Development Facilitation Team (DFT) – Review Comments

Project No: PR-2022-007903 Date: 1/22/2025 Agenda Item: #1 Zone Atlas Page: L-20

Request For: Incorporate vacated portions of Santa Clara Ave, Altez St and Erbbe ST SE Right-of-Way with adjacent properties and dedicate private and public easements as shown and to create one new lot.

Application For: SD-2025-00001 – PRELIMINARY PLAT

PLAT OF
TRACT A1 OF BLOCK 26, LOTS 5A, 6A,
7A, 8A, 9A, 10A OF BLOCK 25
— AND BLOCK 56-A1 & 56-A2

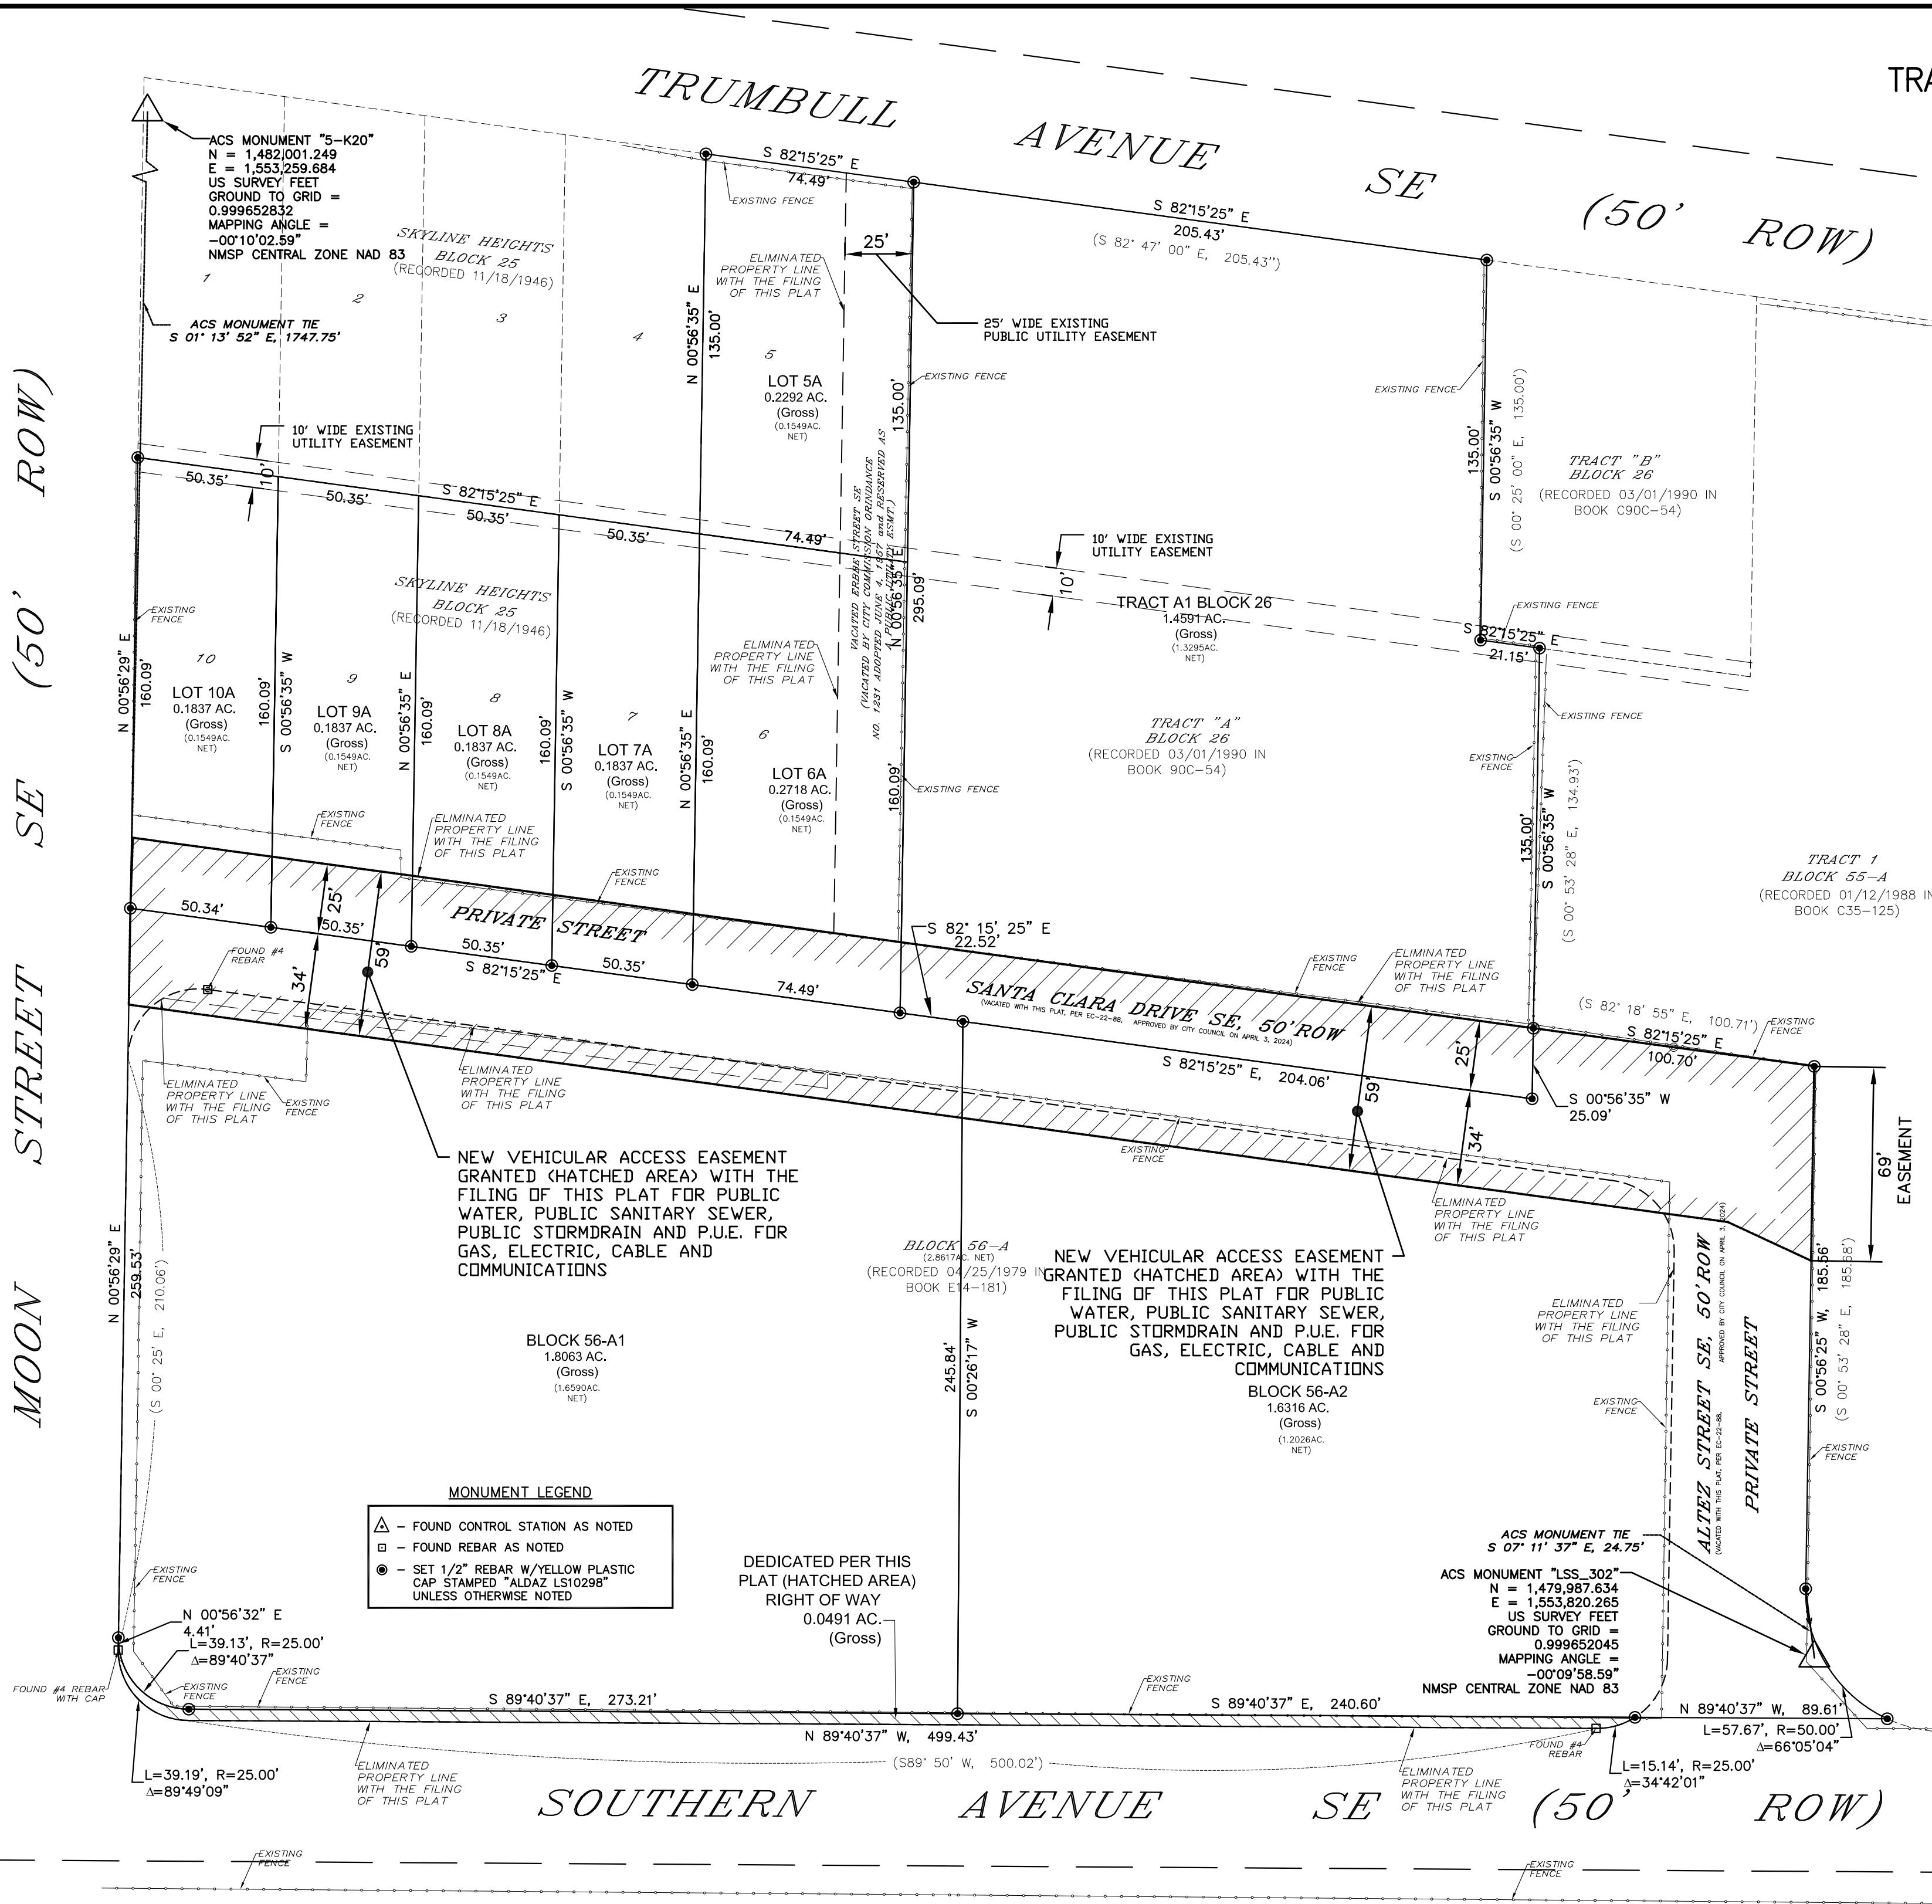
- Add a note to the plat stating approval of the vacated right-of-way of Santa Clara Ave. SE and Altez St SE by City Council with date.
- Planning defers to Transportation regarding the Sidewalk Waiver request and its compliance with 6-6(P)(3) of the IDO.

- Applicant has provided an Infrastructure List to provide/repair sidewalks on Southern Blvd and Moon St.
- Project and application numbers must be added to the Plat and Infrastructure List.
